WELWYN HATFIELD COUNCIL – DEVELOPMENT CONTROL
DELEGATED REPORT

APPLICATION No:	S6/2007/539/FP
------------------------	-----------------------

This application seeks full planning permission for a loft conversion incorporating side dormer windows and additions to the front and rear to form a gable roof.

PROPOSED LOFT FLOOR LAYOUT

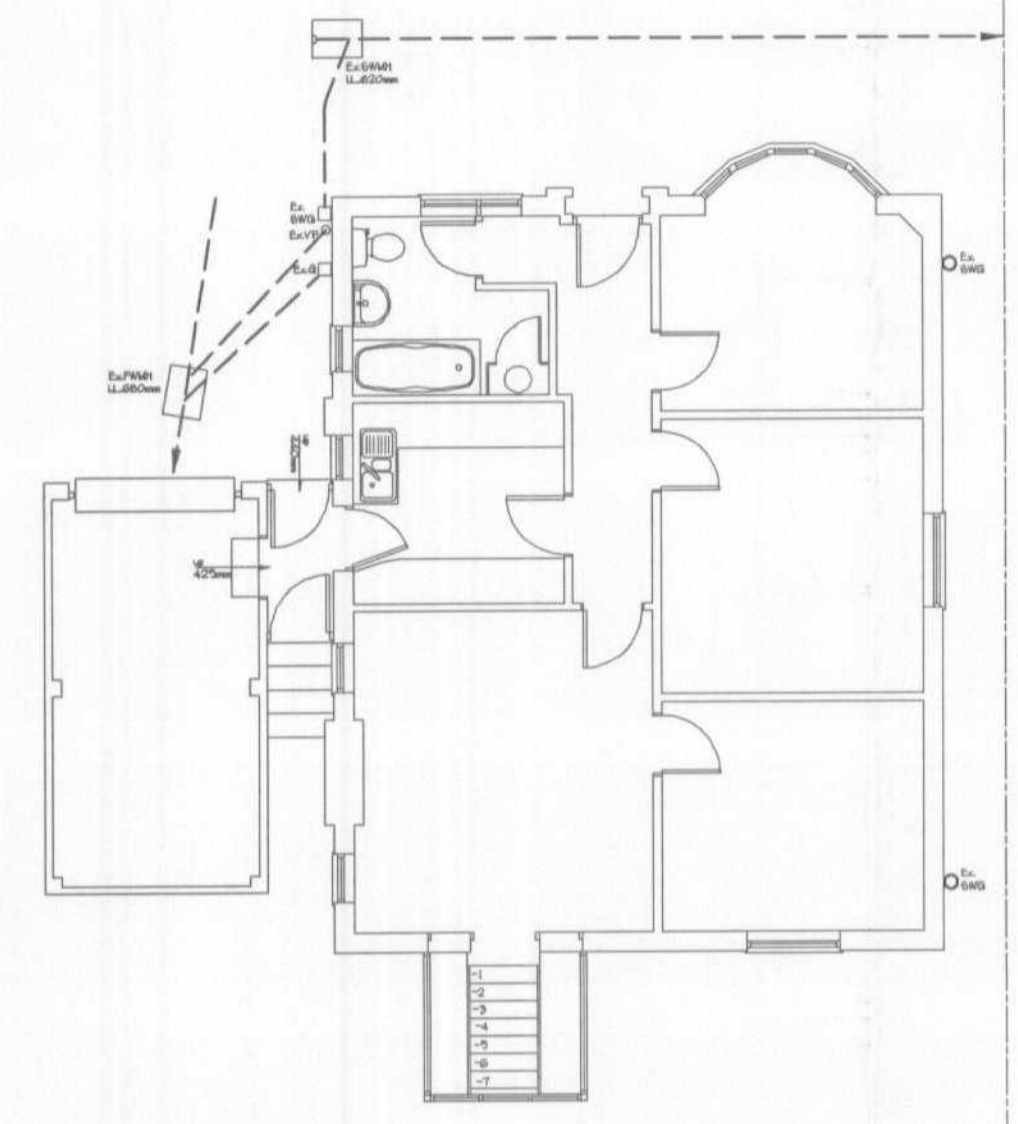
The flat roofed side dormers project approximately 1.5m either side of the existing ridge effectively squaring off the dwelling when viewed from the front. The south side dormer measures 2.4m in length and features two windows, one to a bedroom and one to the shower room. The north side dormer measures 3.5m in length and features two windows to bedrooms. It is also proposed to create a gabled front and gabled rear to the bungalow each with a window at the centre.

Turning to amenity issues, the proposed first floor windows in the front and rear elevations would not create any additional overlooking. To the rear approximately 73m separates the rear elevation of the proposed dwelling and the rear elevation of No.30 Theobalds Road. The size, height and location of the proposed extension would not have an overbearing impact on the occupiers of the adjacent dwellings. A minimum of 1m separation distance exists between the dwelling and the site boundaries. The materials would match those of the existing building including tiles and brickwork. Should the application be granted a condition would be required to insure that the dormer windows in the north elevation are fixed and obscure glazed in order to prevent an unacceptable loss of privacy to the adjacent dwelling.

PROPOSED ELEVATIONS - 1:100

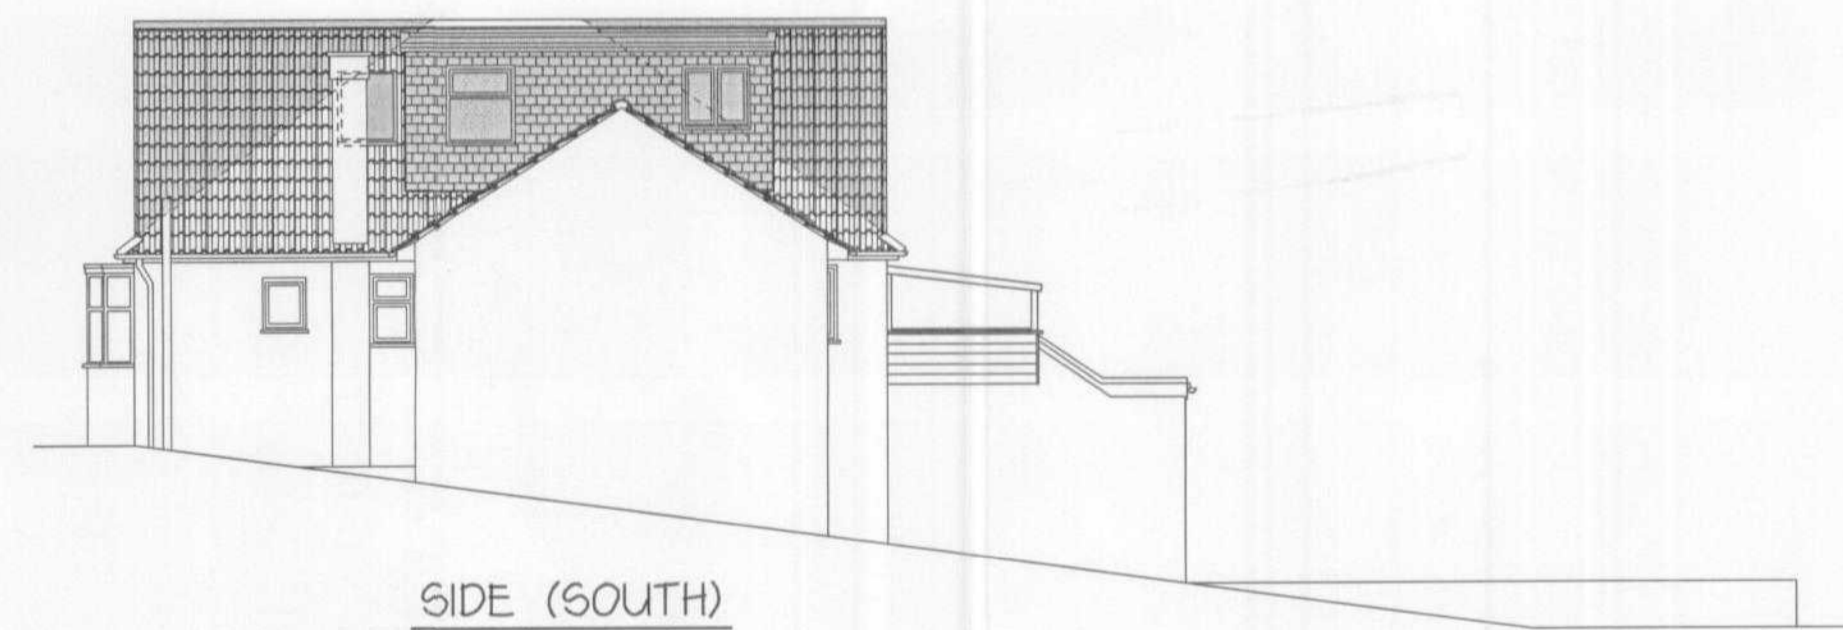
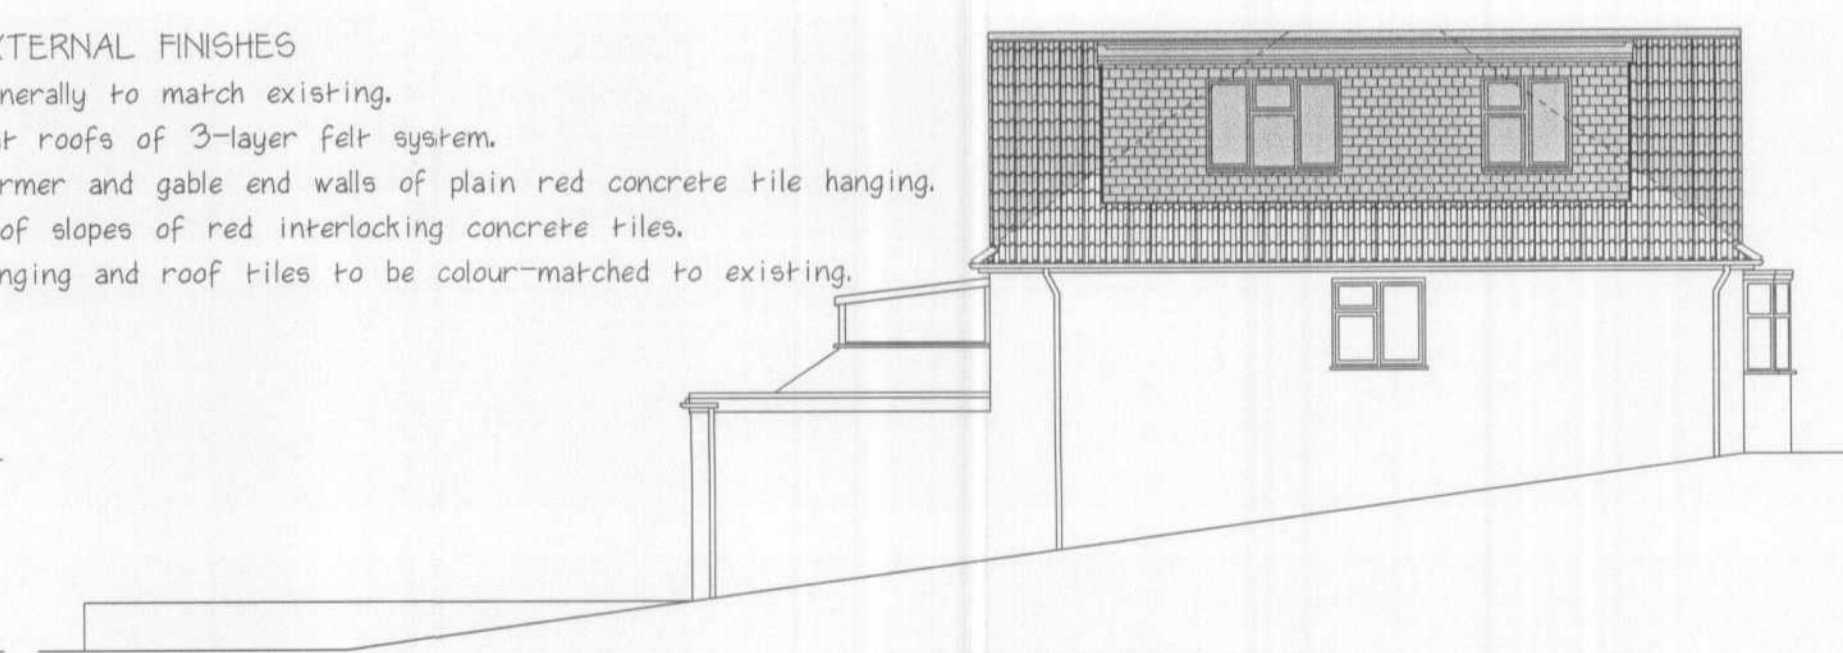
Furthermore, the two sizeable dormer windows would not be subservient to the roof slope and their size and elevated position would make them both prominent and visually dominant in views along parts of the street. The introduction of gabled roof would be uncharacteristic of the immediate street scene.

The extension and roof enlargement would be out of scale with the original bungalow and would introduce additional bulk and mass to the existing bungalow, which would not appear subordinate to the original dwelling. The scale of the proposed extensions would be a dominant and incongruous feature in the street scene and be detrimental to the established character of the immediate area. The proposal therefore fails to comply with Policy D1 of the Welwyn Hatfield District Plan 2005 and Supplementary Design Guidance, February 2005 (Statement of Council Policy).

1. The proposals by reason of their scale, mass and incongruous design would adversely affect the character of the existing dwelling. The two large side dormers and the introduction of a gabled roof would create a roofscape which is not subservient to the original dwelling. The proposals are therefore contrary to Policies D1 and D2 of the Welwyn Hatfield District Plan 2005 and Supplementary Design Guidance (Statement of Council Policy).

2. The proposed side dormers to the northern and southern elevations facing No.56 and No.60 Northaw Road East would be likely to have a detrimental impact on the current or future occupiers ability to implement a similar development due to privacy issues, and would thereby be contrary to Policy D1 of the Welwyn Hatfield District Plan 2005 and Welwyn Hatfield Supplementary Design Guidance February 2005 (Statement of Council Policy).
